PCU078297

Application SSI 7485

I write as a resident of Johnston Street concerning the proposed changes to the M4-M5 Link Mod 2.

Figure 4-5 The Crescent/Johnston Street/Chapman Road intersection

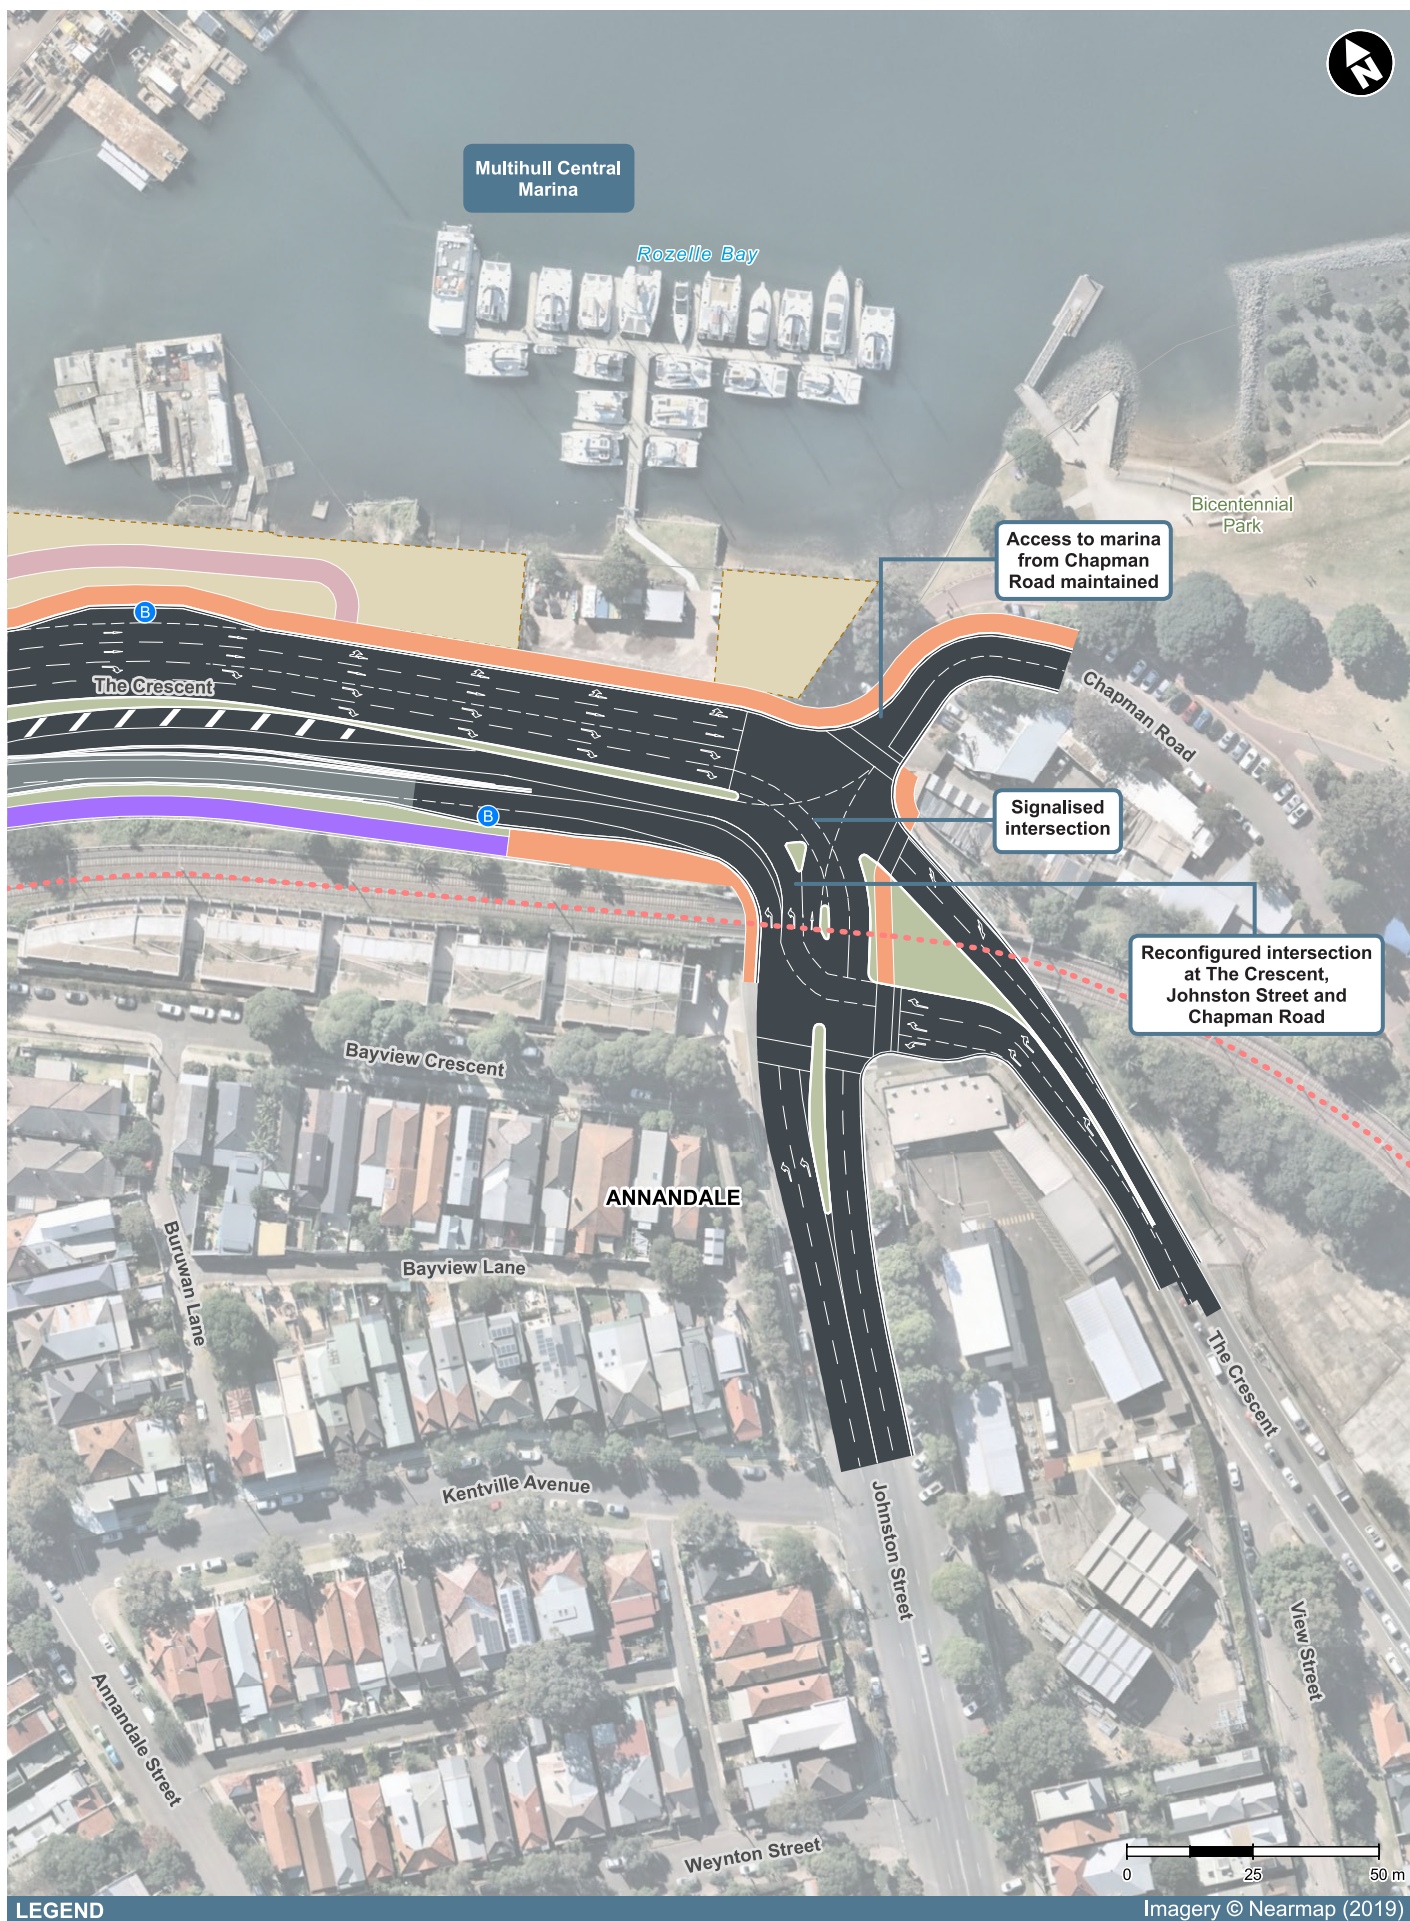
1. In order to walk from Johnston Street to the Glebe foreshore, the new plan imposes a complex route involving 4 set of traffic lights.
2. For drivers, the R turn from Johnston Street to the Crescent will be eliminated. So, for instance, to visit the Tram Shed by car will now involve a large detour.
3. The new flyover is huge and out-of-character.
4. The loss of the covering of the M4/M5 motorway by a green park is a huge reduction in amenity value.
5. The partial loss of visibility of the Street Mural represents a loss of modern history of the area.
6. The revised plan, particularly the 2 lanes of R turn from the Crescent into Johnston Street will further increase the traffic in the residential road with multiple primary schools.
